CITY OF ALBUQUERQUE

March 22, 2019

Site: PRESNow on Coors

Re: Drainage Ordinance (14-5-2-1) Violation for Erosion and Sediment Control

EROSION AND SEDIMENT CONTROL PLAN

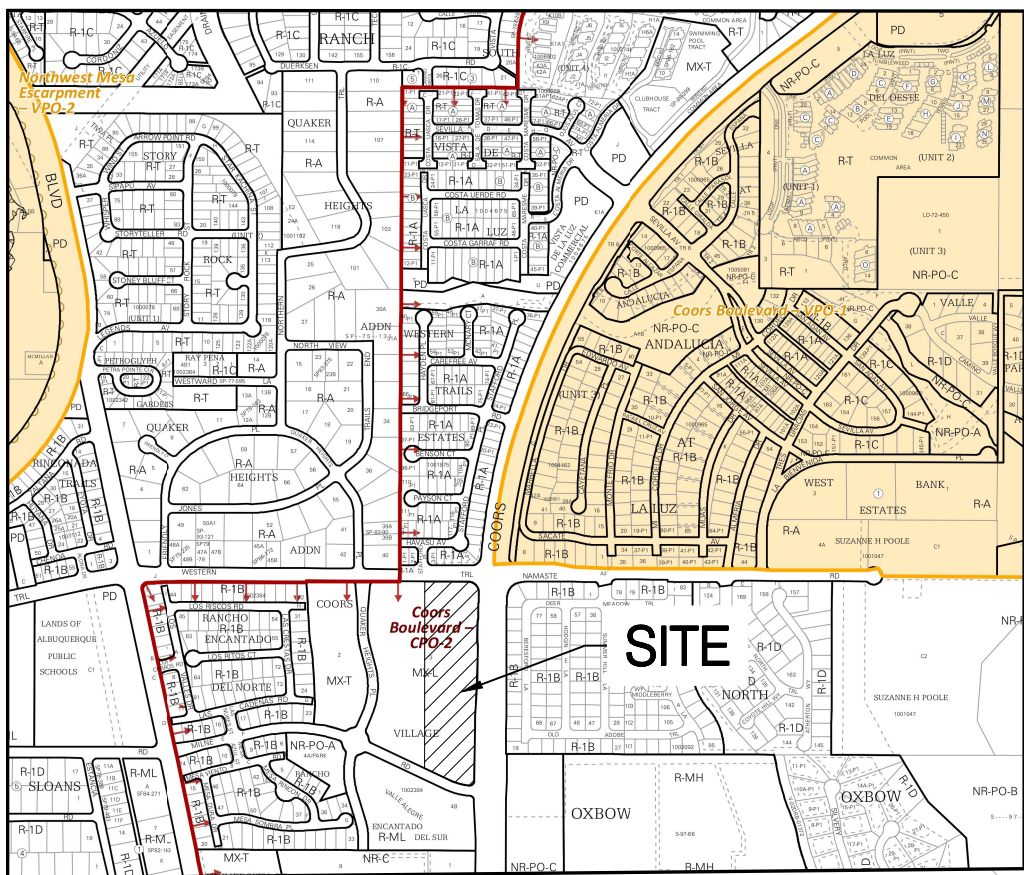
1. Earth disturbance has begun at the site and stormwater controls have not been implemented.
2. Sediment track-out onto the street.

1. Install stormwater controls per the approved Erosion and Sediment Control Plan.
2. Have sediment controls in place for the duration of the project.
3. Remove sediment from the street.
